Sl.No. A2/7925/96 dated 8.5.1996

Sub: MMDA - Planning Permission - Construction of

GF+FF residential building at Plot No.107&108,
Chidambaram Nagar in S.No.3/85 and 3/06 of
Sholinganallur village -

SITE PLAN

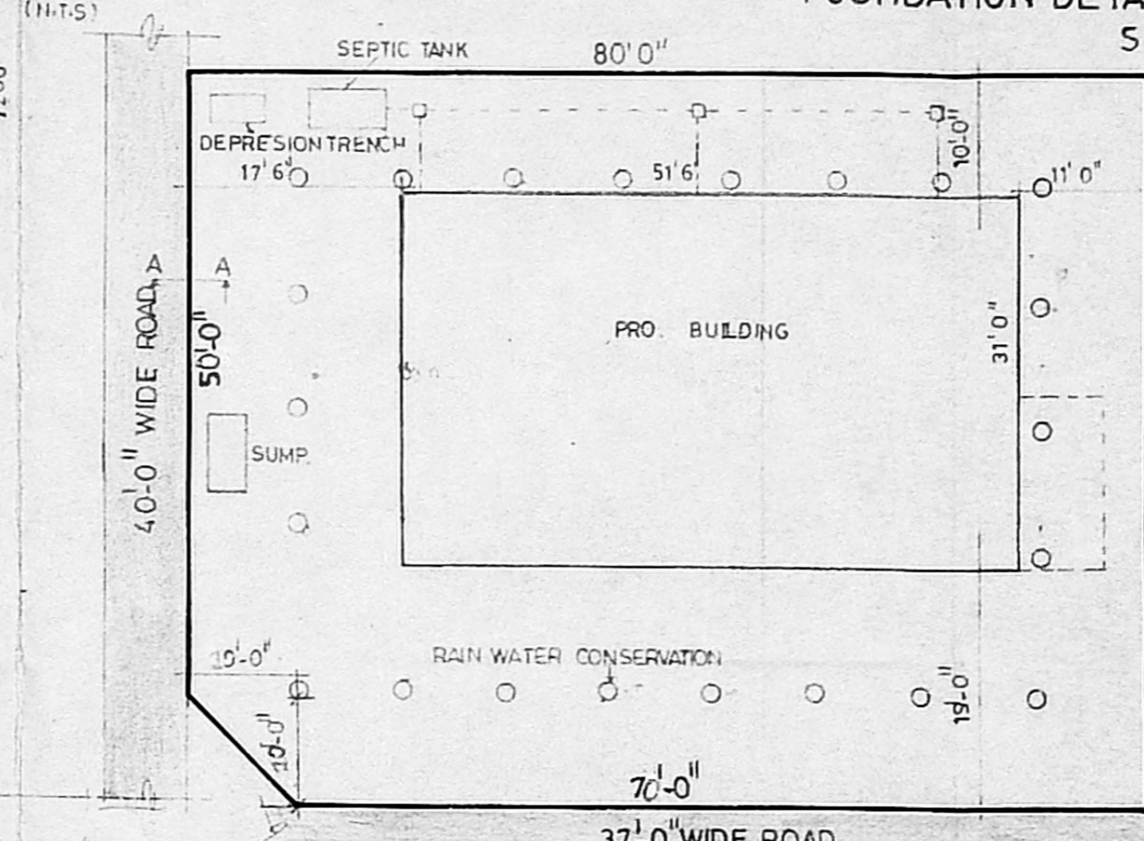
- a) Rain water conservation regulations notified by MMDA, should be adhered to strictly.
- b) 5 copies of revised plan satisfying floor set back, display and marking the road on eastern side with road width.
